Council Reference: DA21/0233 LN 41917  
Your Reference: SSD-10398

4 June 2021

**Tweed Shire Council Submission – Hanson Tweed Sand Plant Expansion -  
State Significant Development (SSD-10398)**

I refer to the Department's request for Council's advice / comment on the Environmental Impact Statement (EIS) for the Hanson Tweed Sand Plant Expansion (SSD-10398). Council officers have undertaken a review of the proponent's EIS and supporting documentation and provide the following comments for the Department's consideration.

Appendix A3 – Existing & Proposed HTSP Footprint

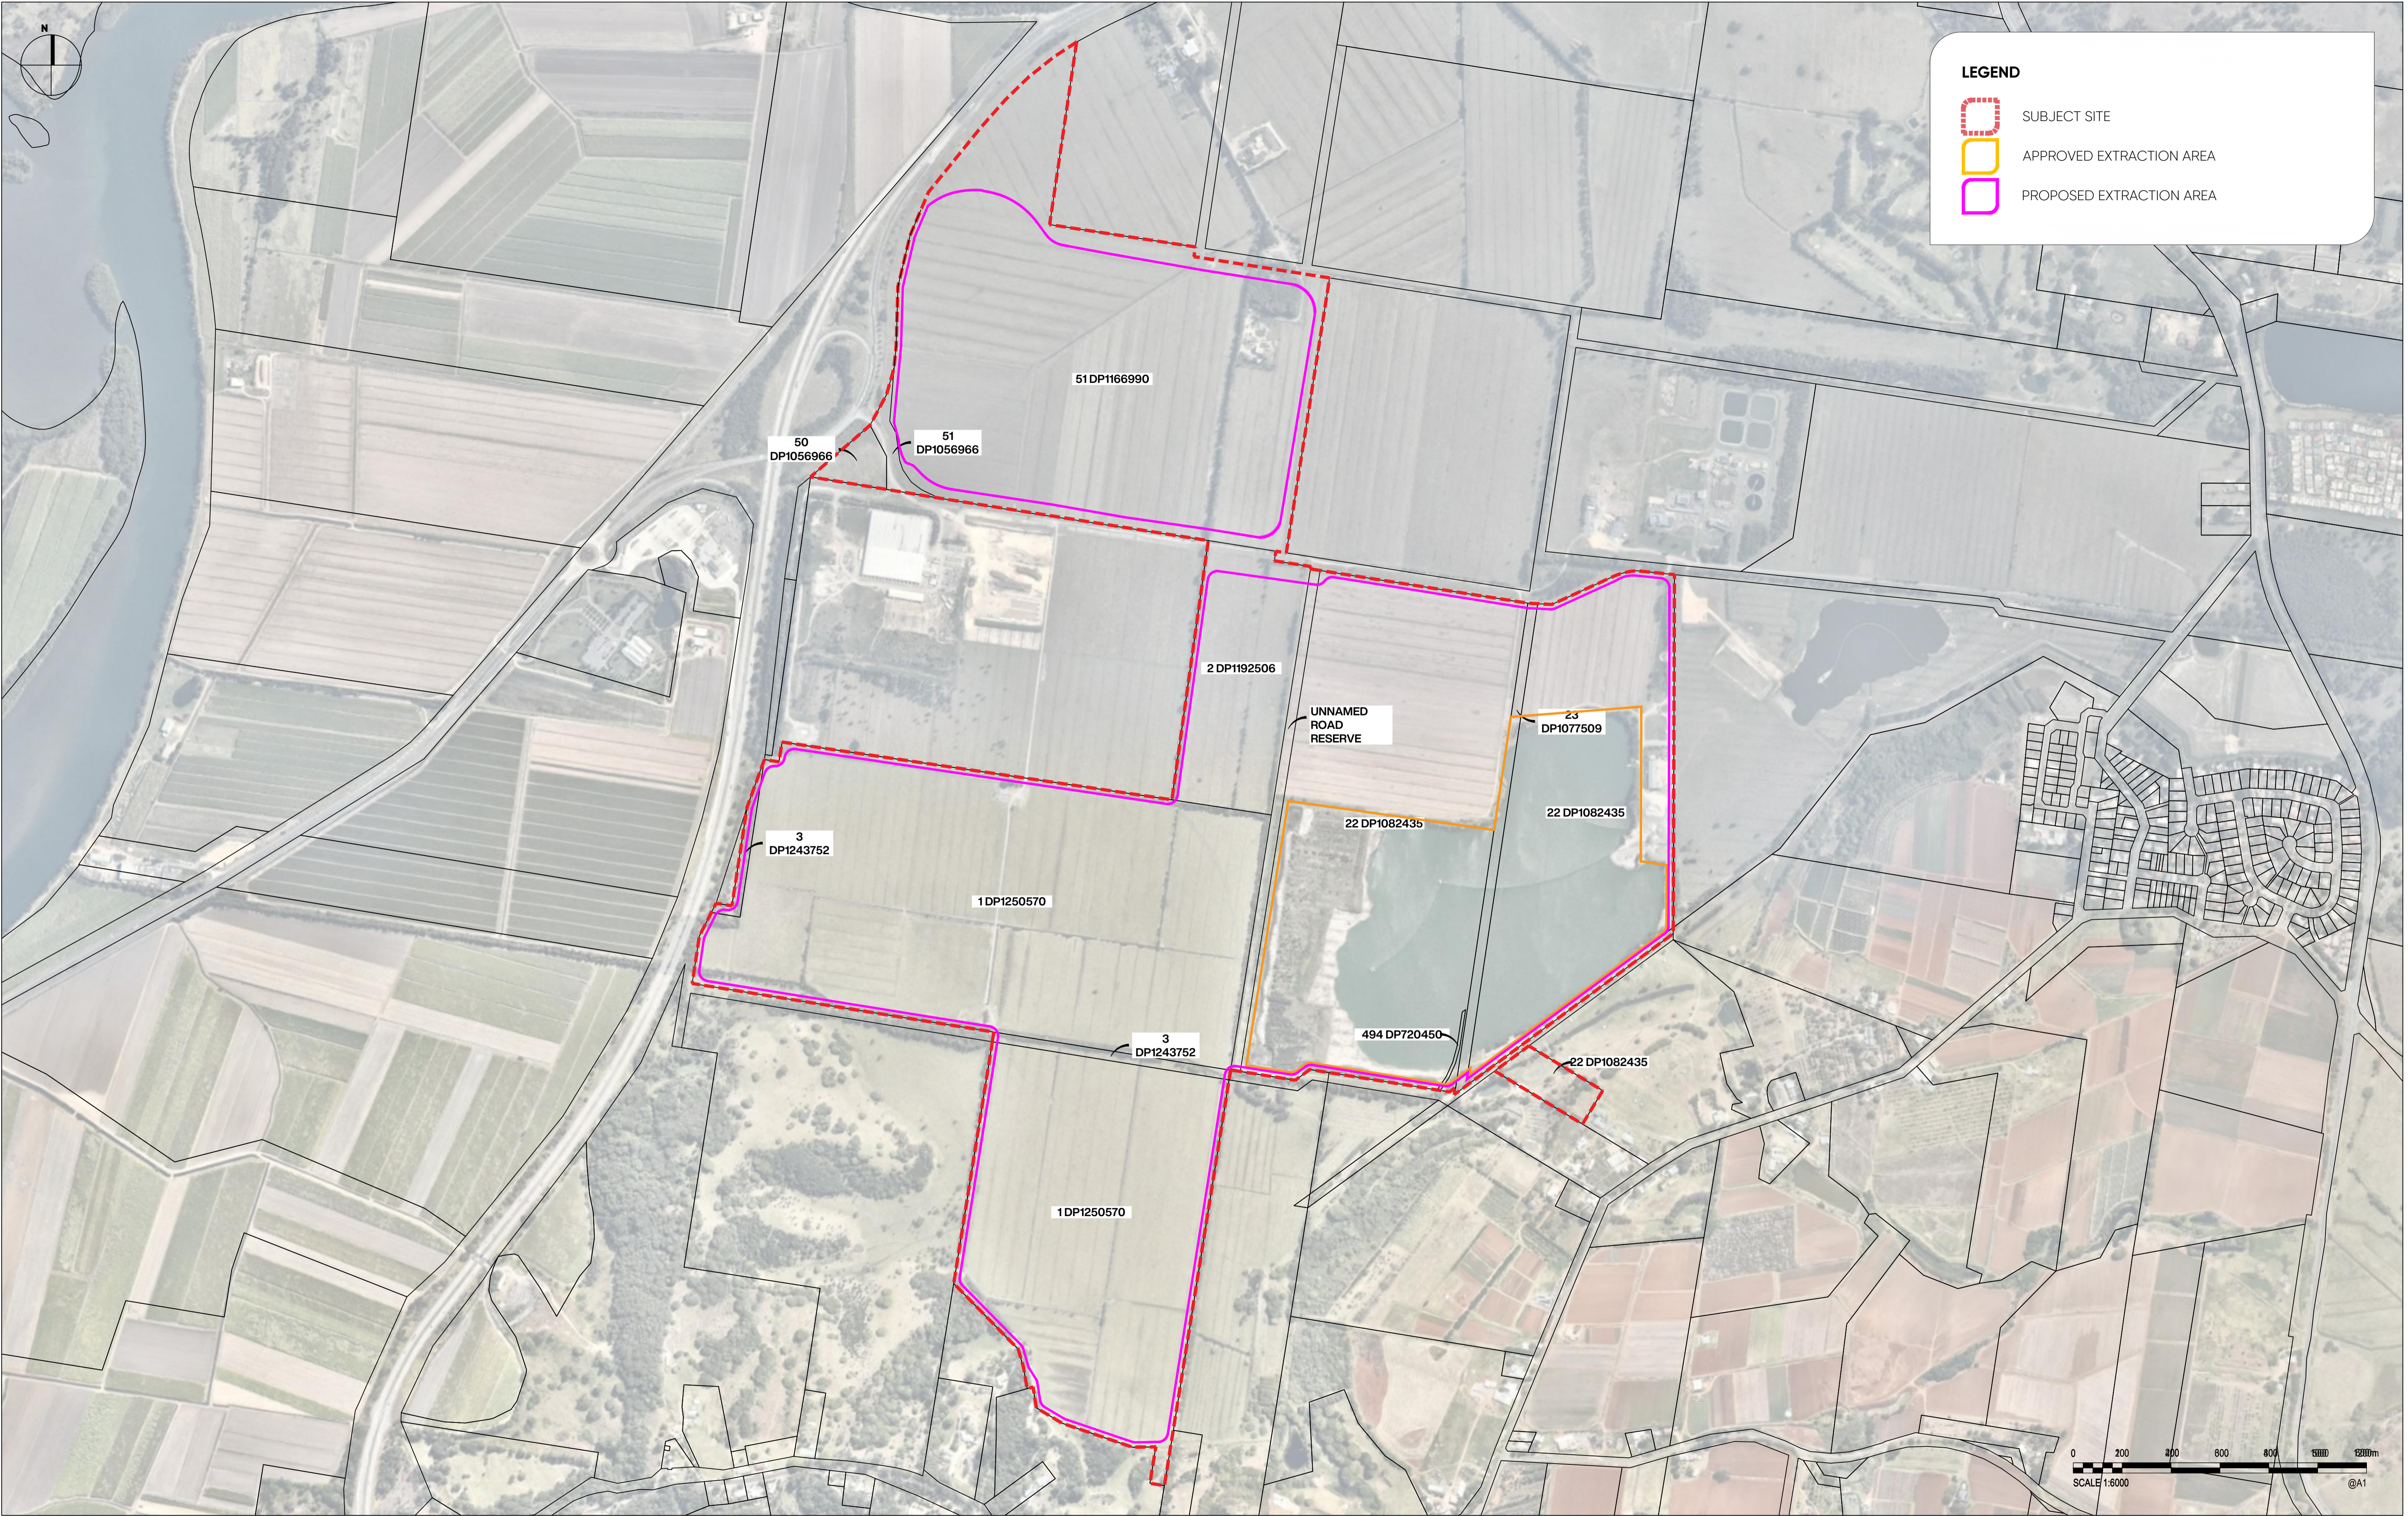
The proponent's FSA suggests that the proposed lake is to be bunded to RL 1.3m AHD. This will result in a bund approximately 0.8m high being placed directly downstream of the highway culverts. It should be noted this is a flow path of critical importance. It is the primary access to the wider Chinderah/Kingscliff flood storage. Any obstruction to flow here is likely to have significant impacts upstream.

The proponent's flood impact assessment does **not** include the bunding of 'Lake 2' to RL 1.3m AHD. The FSA states that:

Council does not agree with the above statement. Whilst this may be valid for some areas of the proposed lake expansion (where existing topography is already around RL 1.3m AHD) it is not true of the critical high flow area adjacent to the Pacific Motorway culvert/bridge. An 800mm high bund in this area is likely to pose a significant barrier to flood waters entering the Chinderah/Kingscliff storage area and therefore have significant afflux upstream.

It should be noted that DCP-A3 only permits changes to ground levels up to 300mm in high flow areas (for local drainage purposes). In this case, given the critical nature of the flow path, 300mm would not be automatically considered permissible and this would be subject to detailed flood modelling (with bunding included). Any significant bunding in this area is contrary to DCP-A3 and unlikely to be supported. **This is a significant constraint for the proposal that has not been addressed and may have substantial implications as the ability to bund the lake to RL 1.3m AHD may not be possible.** Refer to request for further information below (Item 8.1).

- a. The proposed Southern lake is to be bunded to RL 1.3m AHD. The proponent's Flooding and Stormwater Assessment does not include this bunding in its flood model as it 'is considered negligible due to its low level compared to the overall flood levels experienced at the site'. The proposal will result in a bund approximately 0.8m high being placed directly downstream of the Pacific Highway Bridge which is a critical flow path for water entering the Chinderah/Kingscliff floodplain storage. Any obstruction to flow here is likely to have significant impacts upstream.

Appendix A13 – Extraction Phasing Plan

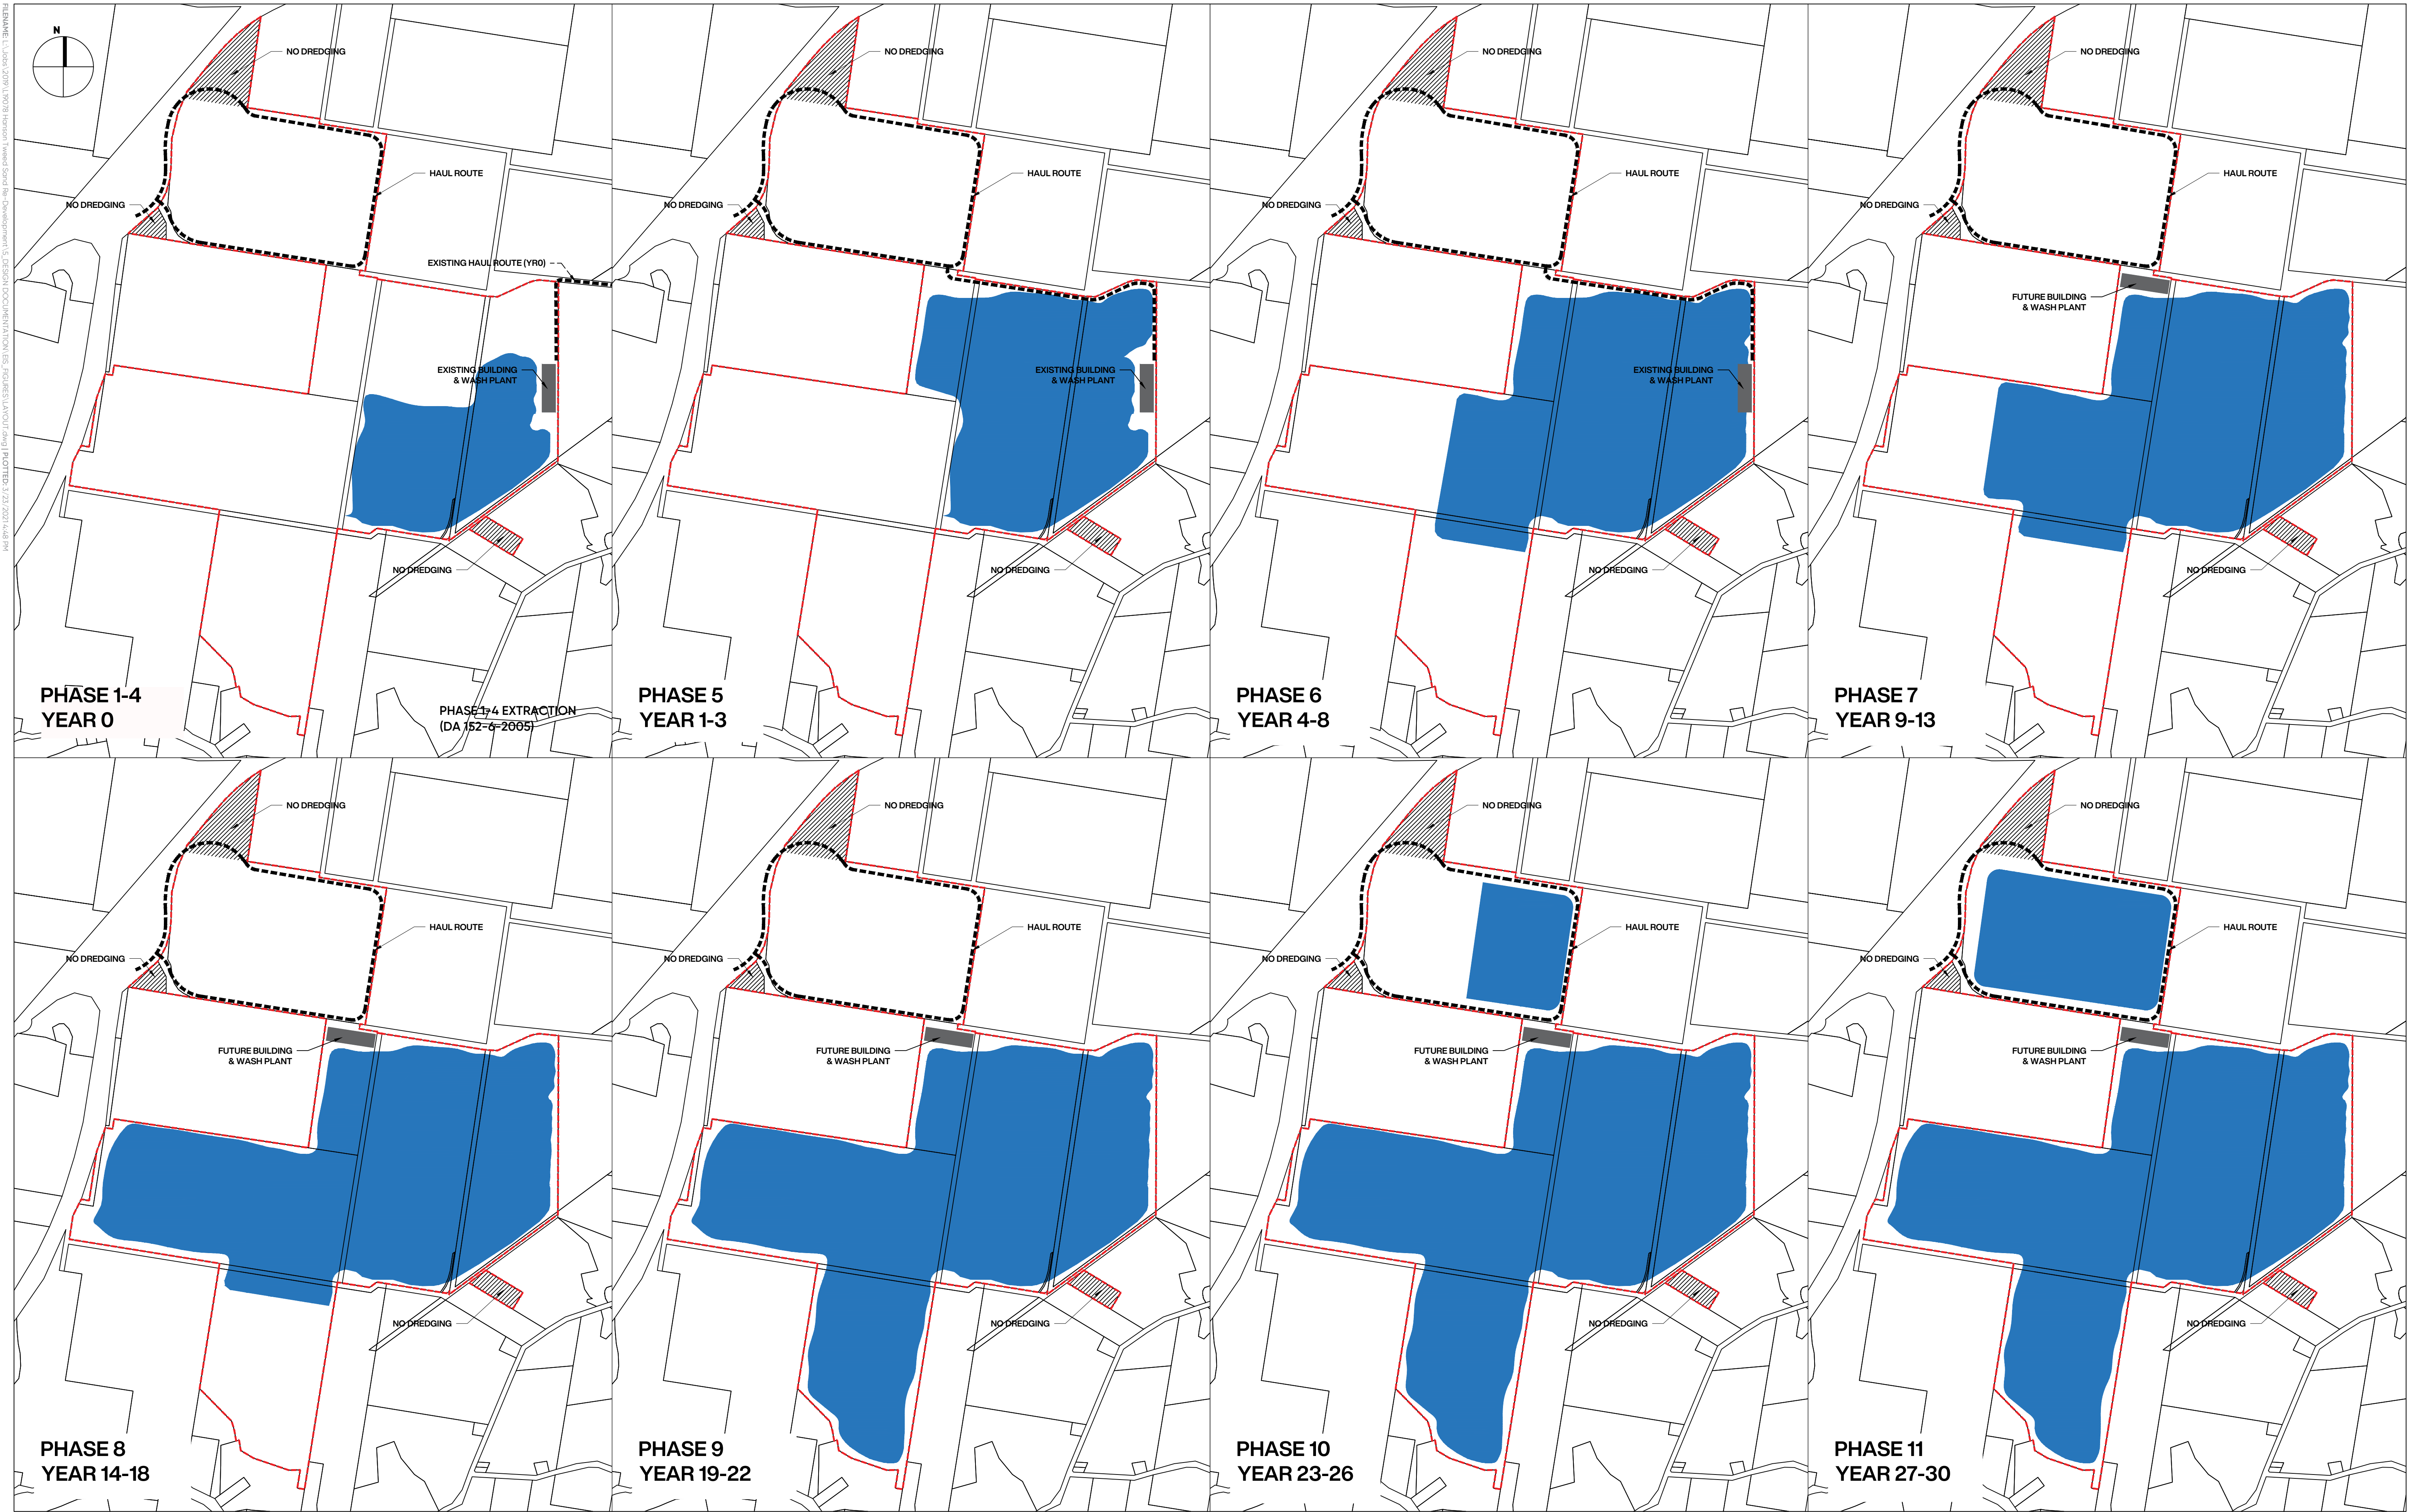
- The proposed development layout design fails to satisfy the avoid and minimise provisions set out in Section 7.2 of the Biodiversity Assessment Method 2020 prepared under the *Biodiversity Conservation Act 2016* resulting in a direct loss of 3.66 ha of remnant mapped vegetation;

- The proposed development layout design fails to satisfy the avoid and minimise provisions set out in the Tweed Development Control Plan Section A19 Biodiversity & Habitat Management resulting in a direct loss of 3.66 ha of remnant mapped vegetation and likely indirect habitat impact by virtue of inadequate ecological setbacks to red flagged values. Opportunities to retain existing vegetation and provide buffers (of minimum 30m width) are highlighted in Figures 2 and 3 below. It is noted that 50m buffers to sensitive high value, poorly represented coastal values is considered appropriate and achievable given the scale of the proposal;

- The proposed layout affects areas identified for rehabilitation as shown in the Revised Rehabilitation and Landscape Management Plan Tweed Sand Plant prepared by JWA Pty Ltd March 2019 under the current extraction approval. See Figure 4 below.

- a. The development layout should be modified to demonstrate how the avoid and minimise principles/provisions specified in the Biodiversity Assessment Method 2020 and Council's Development Control Plan Section A19 Biodiversity & Habitat Management are to be met.
